April 24, 2019

Please find within this letter the written response to the letter received March 26, 2019 on the Kittitas County Maintenance Facility project for the Sign Permit, Permit No. SI-19-00001.

**GENERAL**  
**SIGN ELEVATIONS & DETAILS**

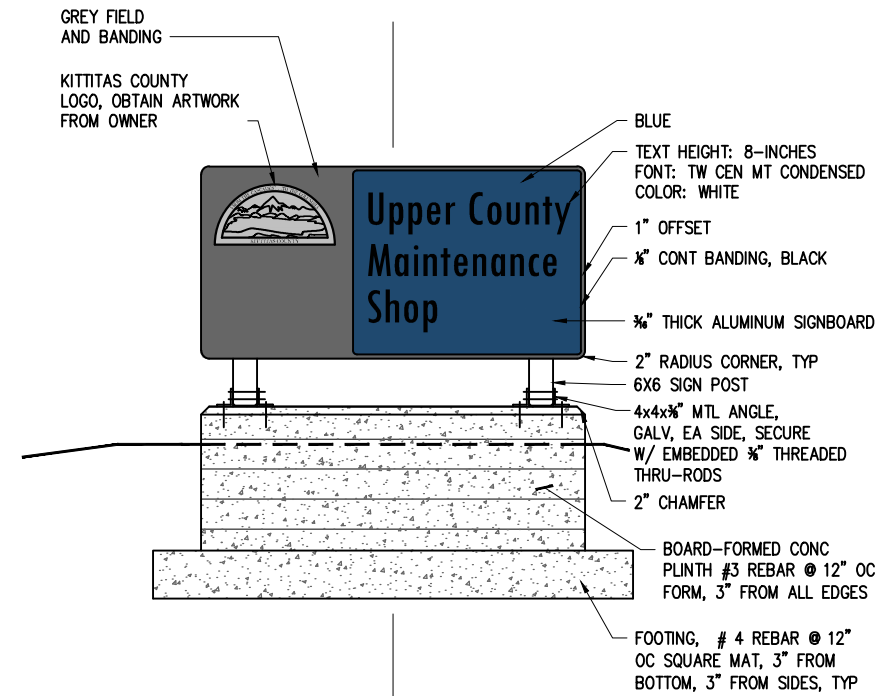
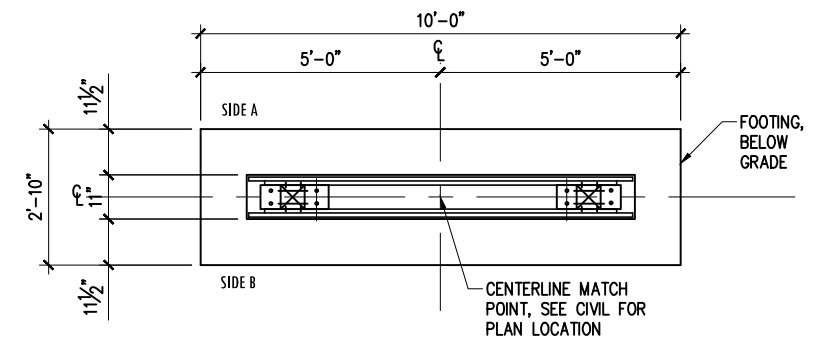
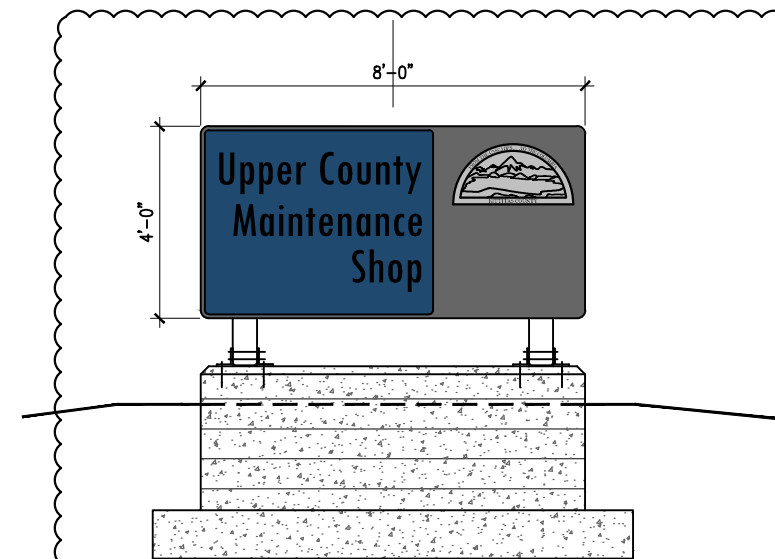
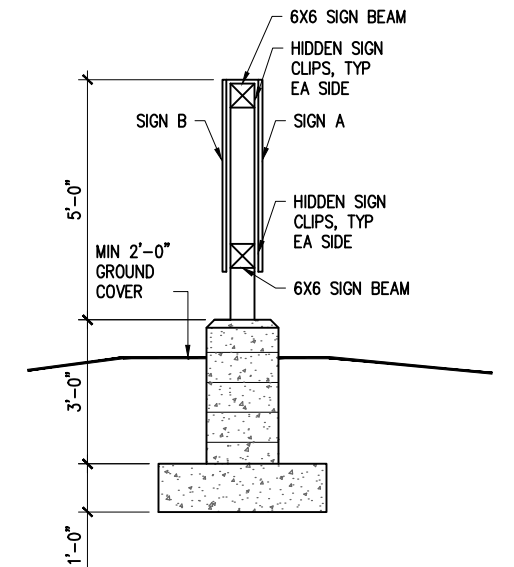
Note 1: The proposed wall sign on the face of the maintenance building appears to meet all criteria under Kittitas County Code (KCC) 17.70 Signs. However, the proposed monument sign near the entrance does not appear to meet the standards given in KCC 17.70.070(1)(b). Under this provision, monument signs are limited to 42 inches above street grade when located within the sight triangle and not taller than 72 inches above finished grade when located outside of the sight triangle. As proposed, the sign is at least 8 feet from grade to the top of the sign. In order to continue processing, the monument sign must be redesigned to meet this provision of KCC.

**Response: The proposed sign is located within the property, which is approximately 25' from the southbound highway lane. Using the standard setback from the existing stop bar on No. 5 Mine road of 8-foot, the driver will be approximately at ROW line, providing unrestricted sight distance within the ROW. The proposed sign will be behind the driver, and have no impact on intersection sight distance. Sheet G1.05 has been updated to provide the size and height of the sign meeting the requirements of the KCC 17.70.**
